Director of Development Services
Ribble Valley Borough Council
Council Offices
Church Walk
Clitheroe BB7 2RA

Drafted 28 December 2011

**Planning Applications, Ribble Valley District
D3/11/0978 12 Nowell Grove, Read**

Ground Floor

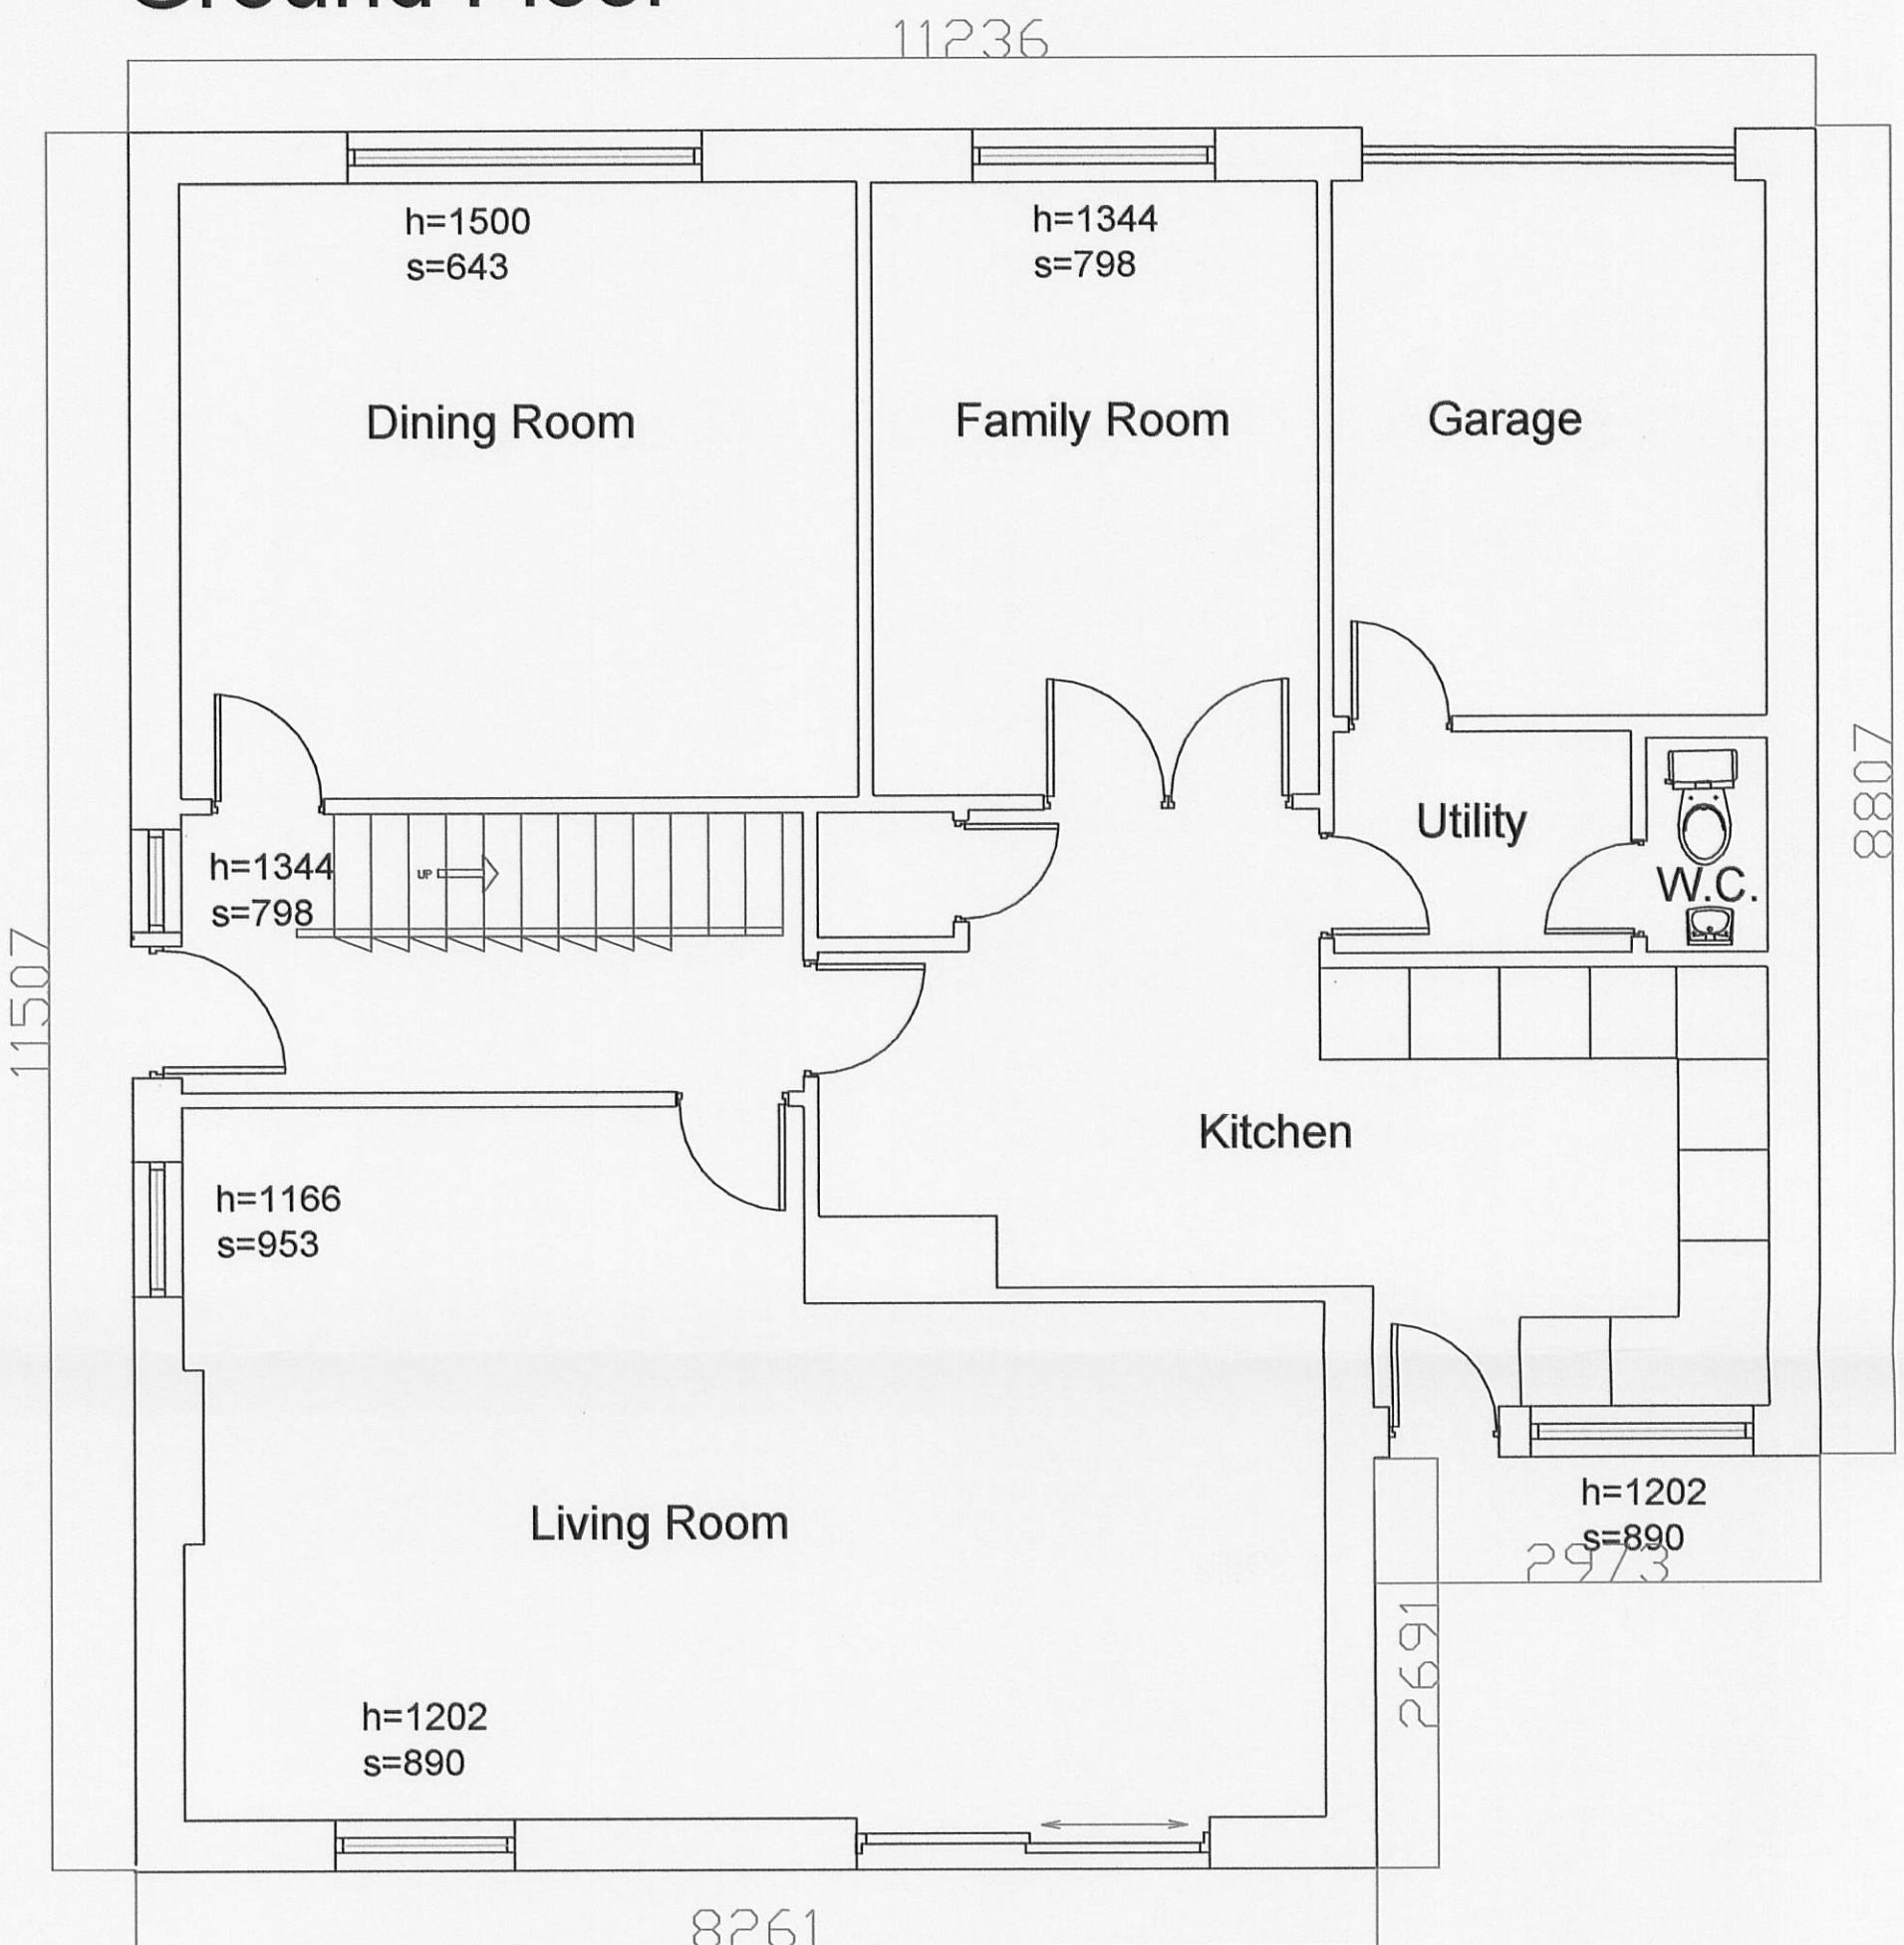
This development will not increase the necessary off street parking requirements as it will continue to be a three bedroom property. However, I would recommend that reference to a garage on the ground floor is not appropriate given that this is space, measuring approximately 3.2m by 3.8m, is not capable of accommodating anything but the smallest private vehicle.
